# CITY OF PORTLAND BUILDING PERMIT

Located At 415 FOREST AVE

Job ID: 2012-03-3459-ALTCOMM

has permission to Install 36" x 36" landing and exit door  
provided that the person or persons, firm or corporation accepting this permit shall comply with all of the provisions of the Statues of Maine and of the Ordinances of the City of Portland regulating the construction, maintenance and use of the buildings and structures, and of the application on file in the department.

Drawing file: Building Permit / 2012-03-3459 altcom Plan..pdf

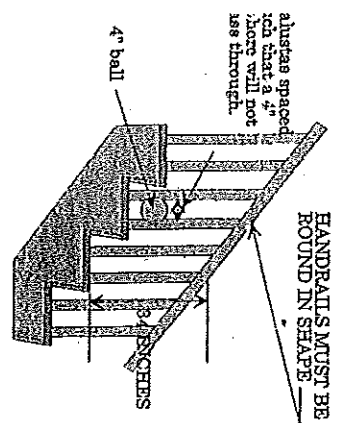
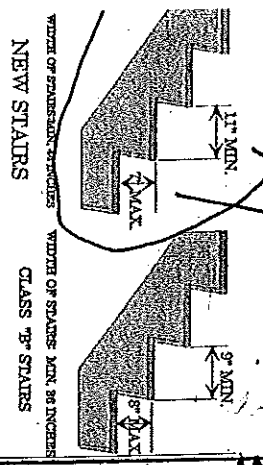
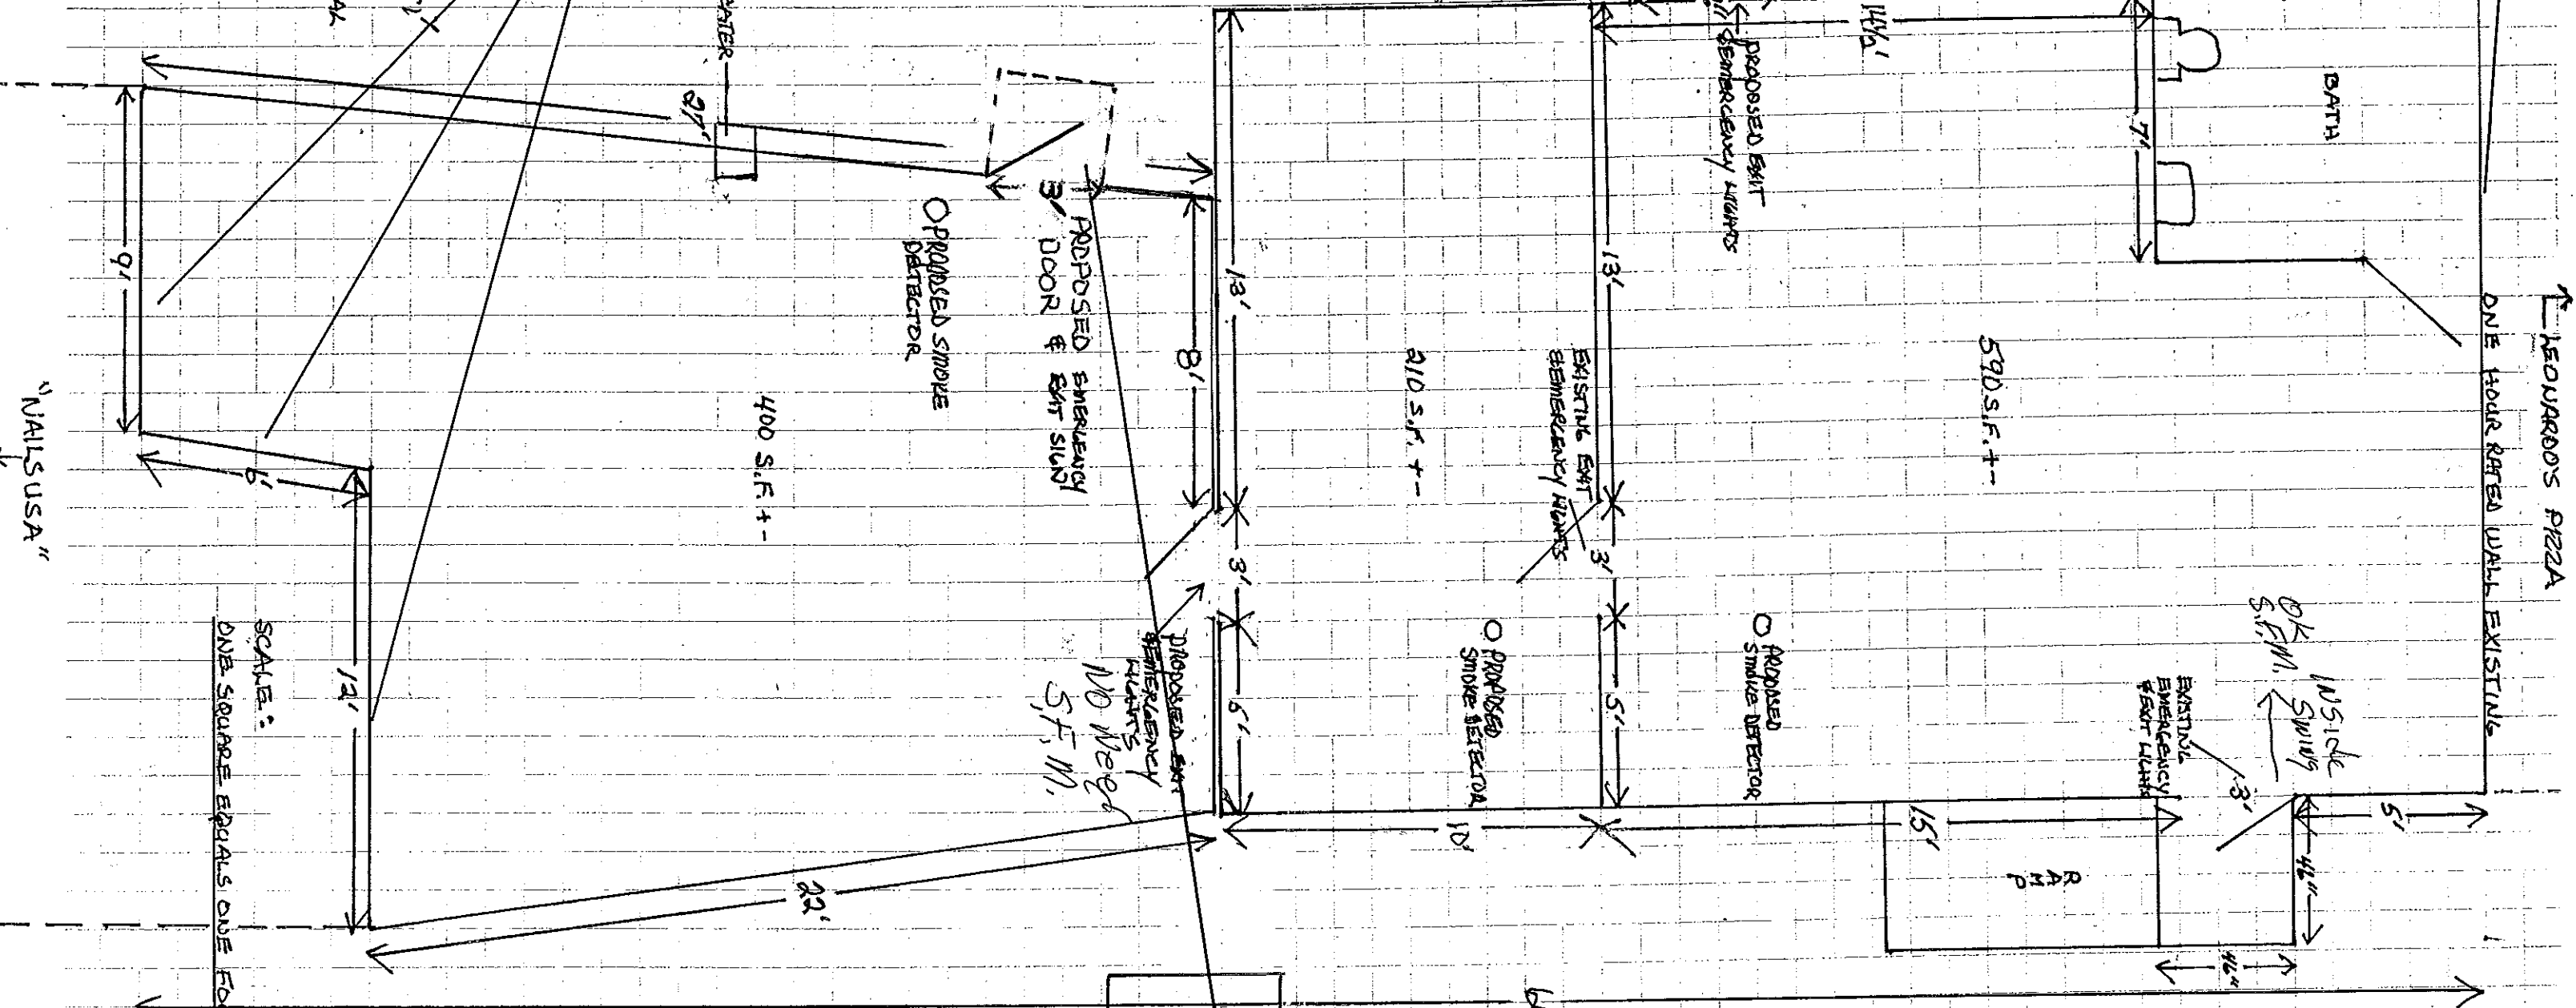
The maximum rise is 7 ¾". The pad must be 7 ¾" high not 8".

✓ ~~1~~ NOSING ON STAIRS INCORRECT

① NEED EXTERIOR LIGHT OVER STAIRS

✓ ② NEED RETURNER GRASPABLE HANDRAILS

✓ ③ OVER 1" DEVIATION FOR STAIRS 5 5/8 TOP 6 5/8 BOTTOM

✓ ④ GUARDRAILS NEED TO 42" / HANDRAIL 34-38"

✓ ⑥ RELOCATE EXIT SIGN OVER NEW DOOR

8-9-12 DWM/BKL/L+Wallace Phil George 802-734-0290 Julie PANS  
Provide coverplate at furnace + thermostat wire separate from 120v. 557-0267  
light at exterior new door
